# CITY OF ALBUQUERQUE

**RE: Parking Redesign  
2500 Louisiana Blvd. NE  
Grading and Drainage Plan  
Engineer's Stamp Date: 7/18/25  
Hydrology File: H19D095  
Case # HYDR-2025-00264**

Based upon the information provided in your submittal received 07/25/2025, the Grading & Drainage Plan **is not** approved for Paving Permit. The following comments need to be addressed for approval of the above referenced project:

# GRADING AND DRAINAGE PLAN

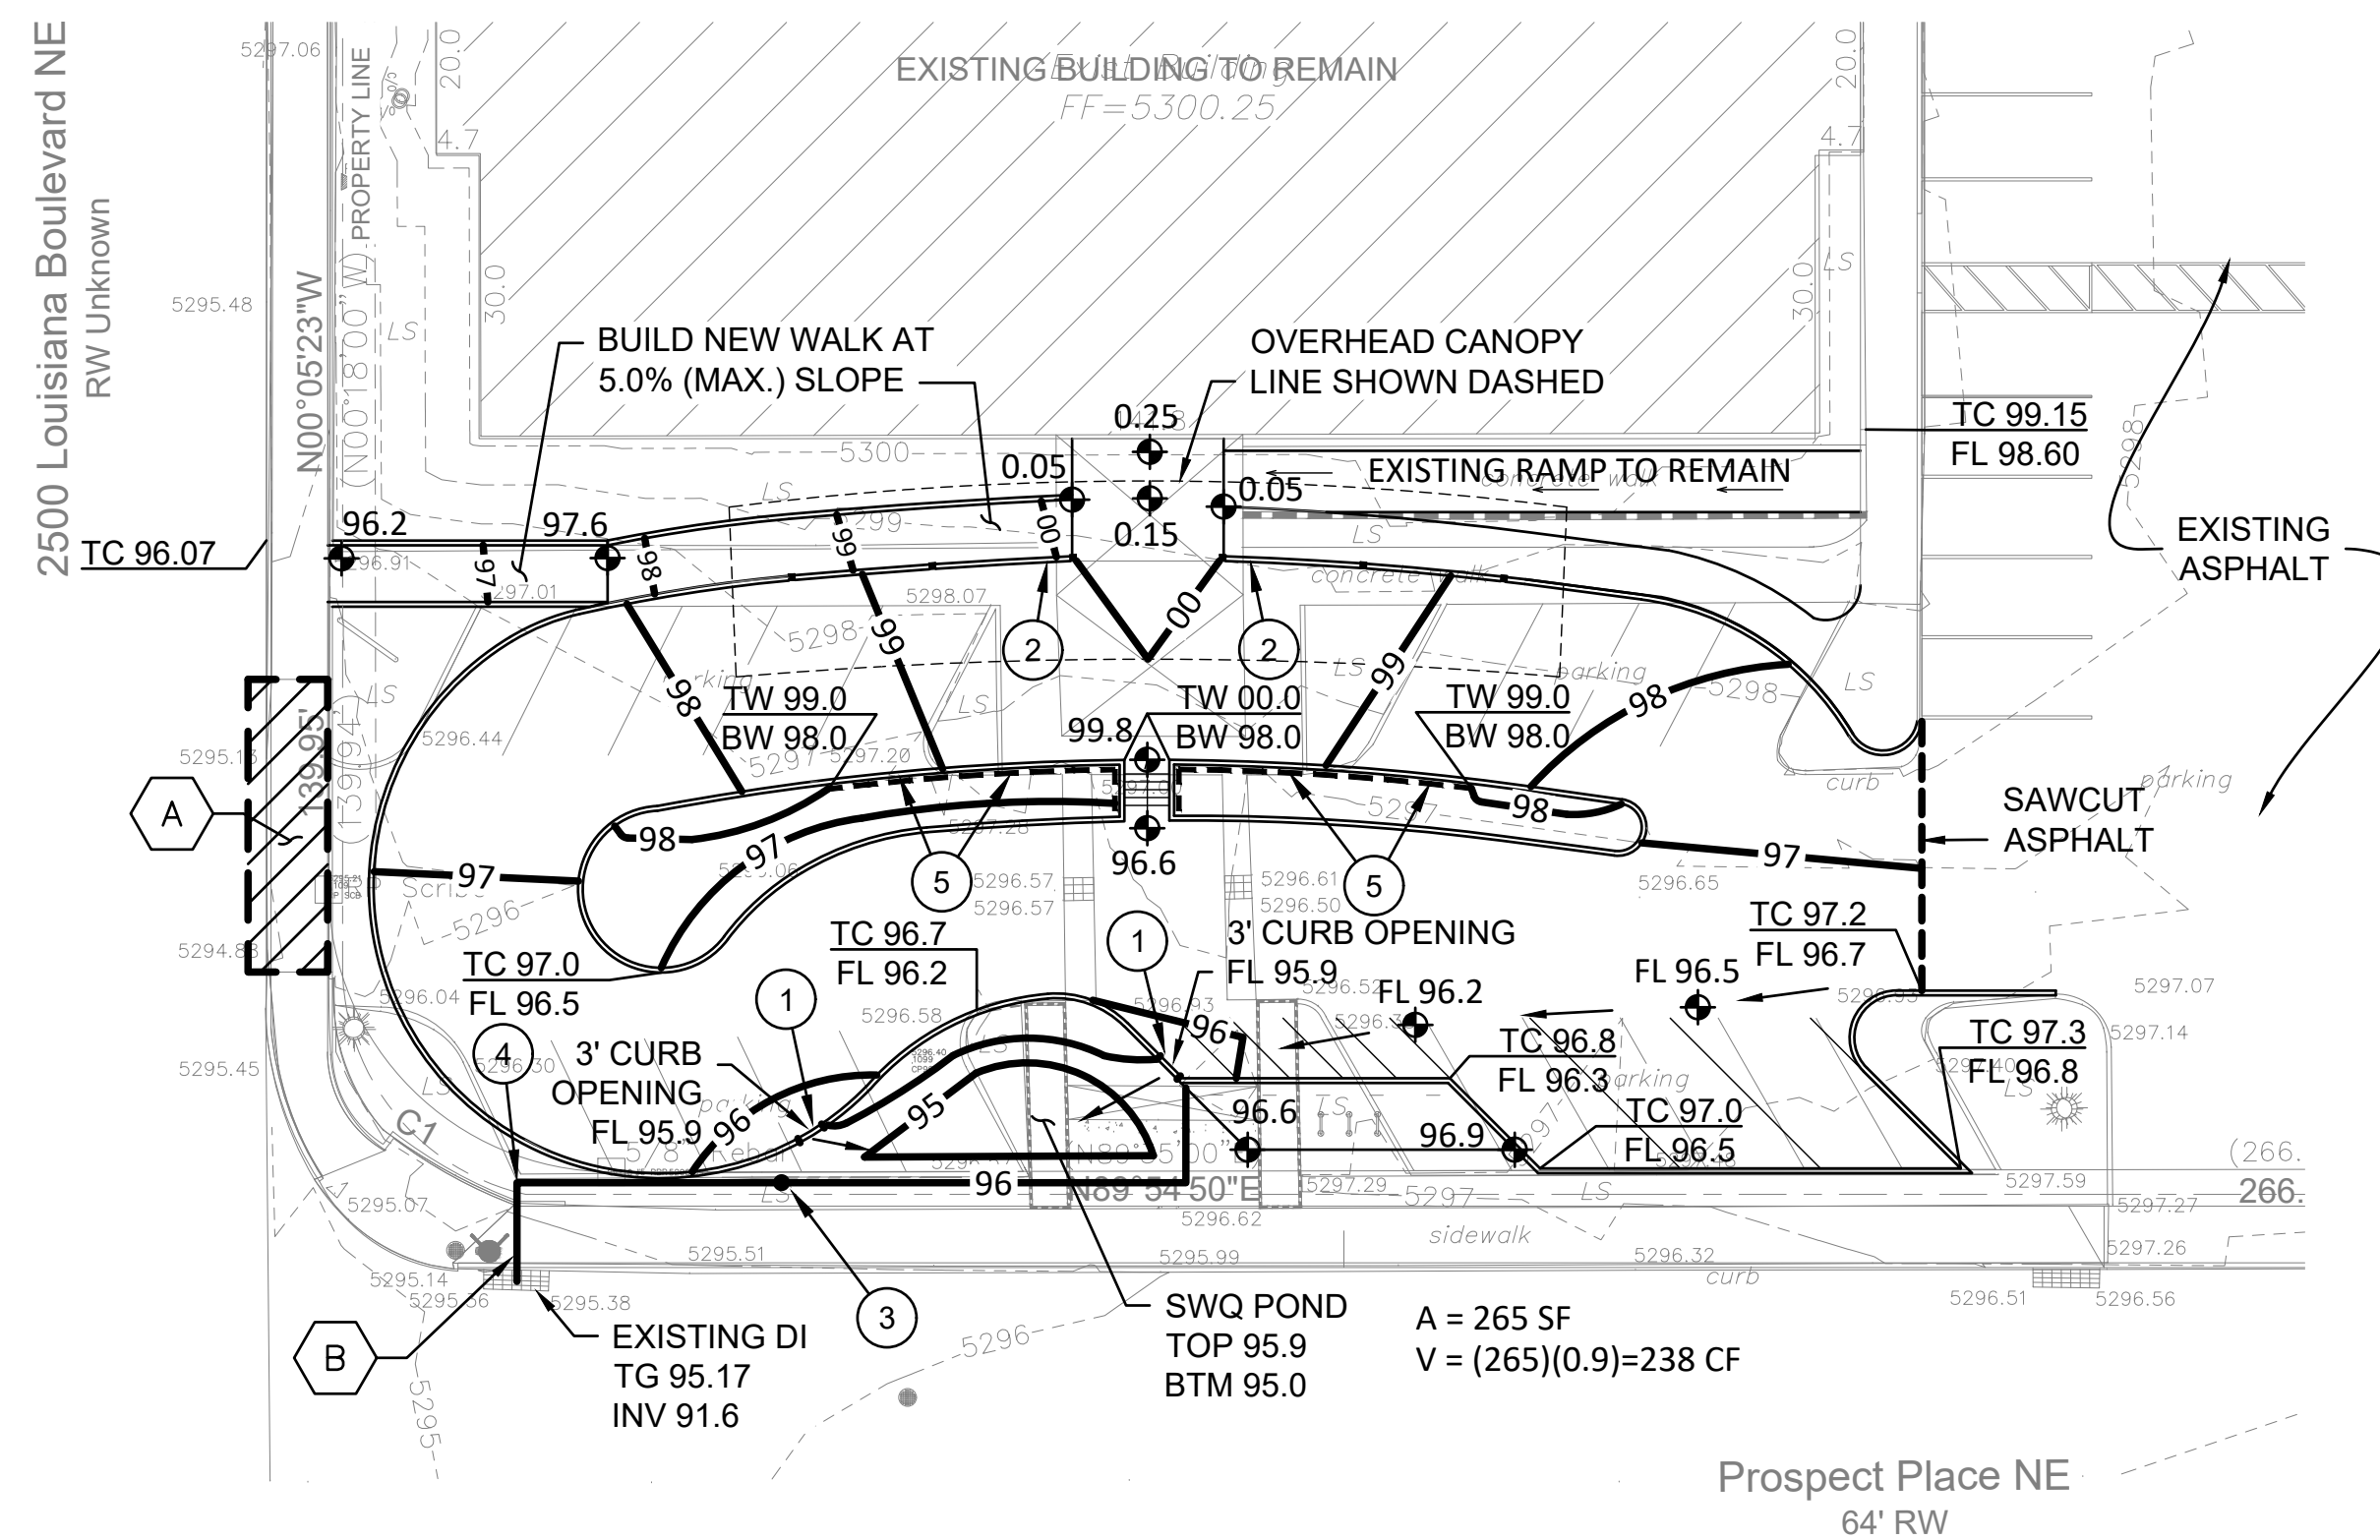
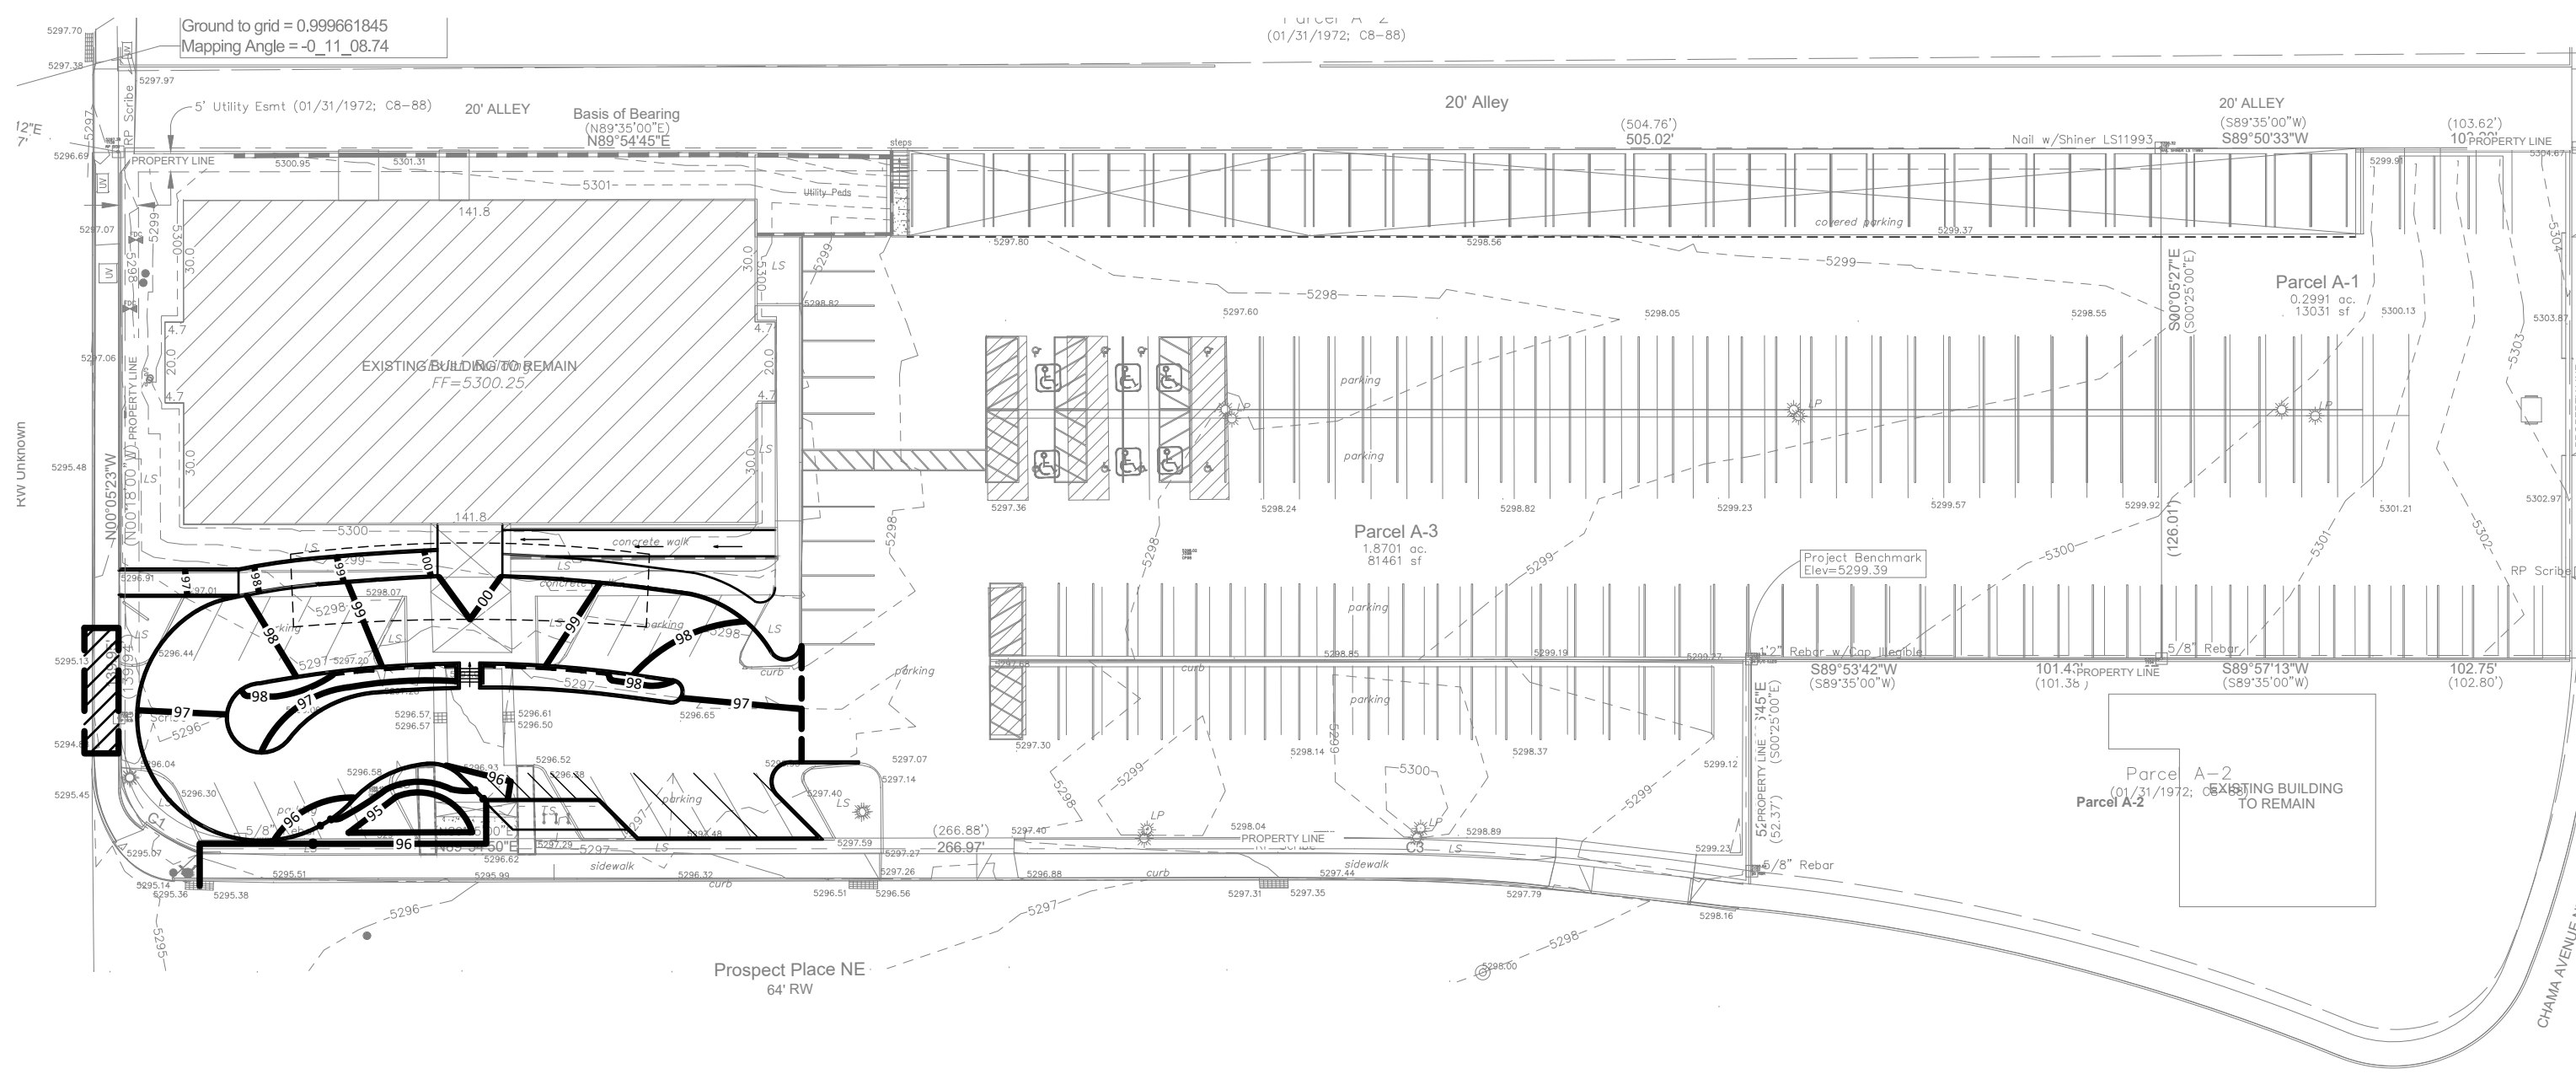
1. Please show the volume for the pond. The calculations of both the required and the provided volume of each BMP must be shown on the Grading and Drainage Plan.
2. If requesting a Waiver of Management Onsite, the following conditions of the new drainage ordinance (enacted 10/2/18) must be demonstrated on the plan (§ 14-5-2-6 (H)):

- public or private off-site facilities provide an opportunity to effectively accomplish the mitigation requirements of this ordinance;
  - there is an opportunity to develop a project to replenish regional ground water supplies at an offsite location; or
  - a waiver to state water law or acquisition of water rights would be required in order to implement management on site.
3. Please show the Payment in Lieu calculation on the plan.
